East Anglia TWO Offshore Wind Farm

**Natural England's Comments on Displacement of Red-throated Divers in the
Outer Thames Estuary SPA – Update [REP5-025]**

Planning Inspectorate Reference: EN010078

24th February 2021

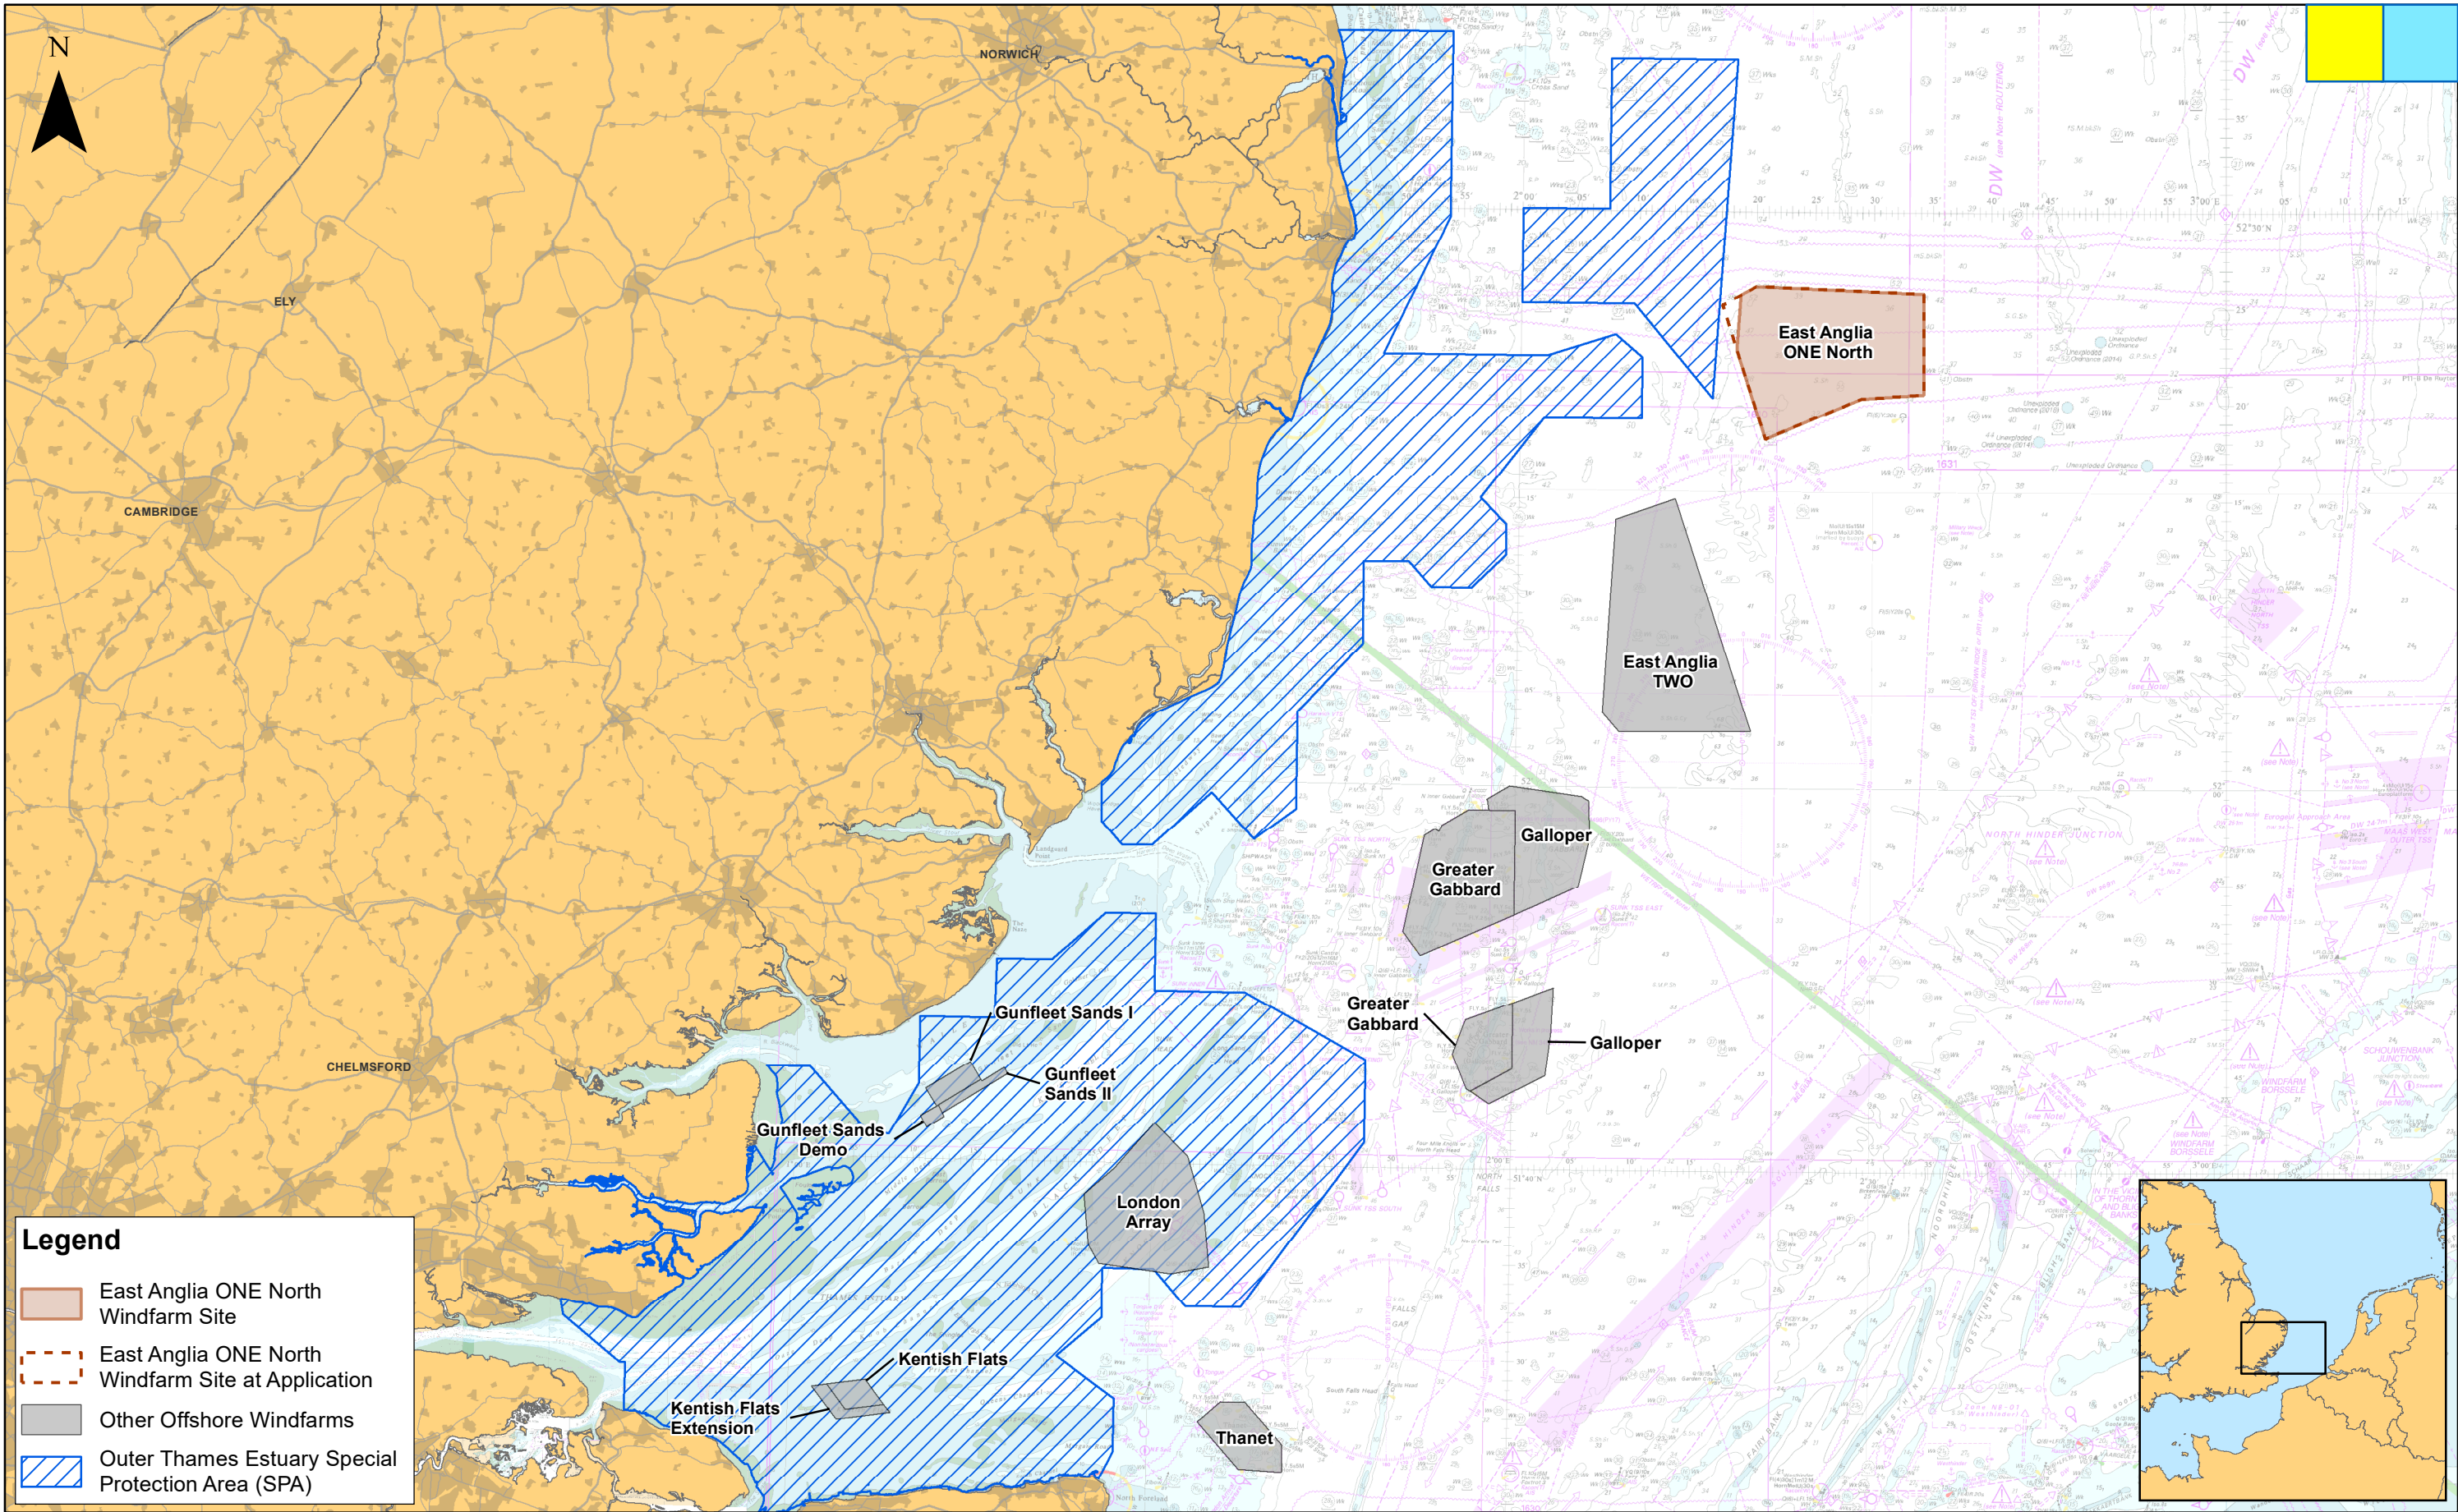
3. As set out in our comments on the Applicant's HRA Derogation case [REP5- 082] **we advise that full consideration is given to a revised project design to enable at least a 10km buffer between the Outer Thames Estuary SPA and the EA1N array, in order to avoid an adverse effect.**
4. In addition, impacts from EA2 also need to be taken into consideration in the assessment for the area 8-12km from the SPA boundary. We continue to advise that an adverse effect on integrity cannot be ruled out for EA2 in-combination with other plans and projects.
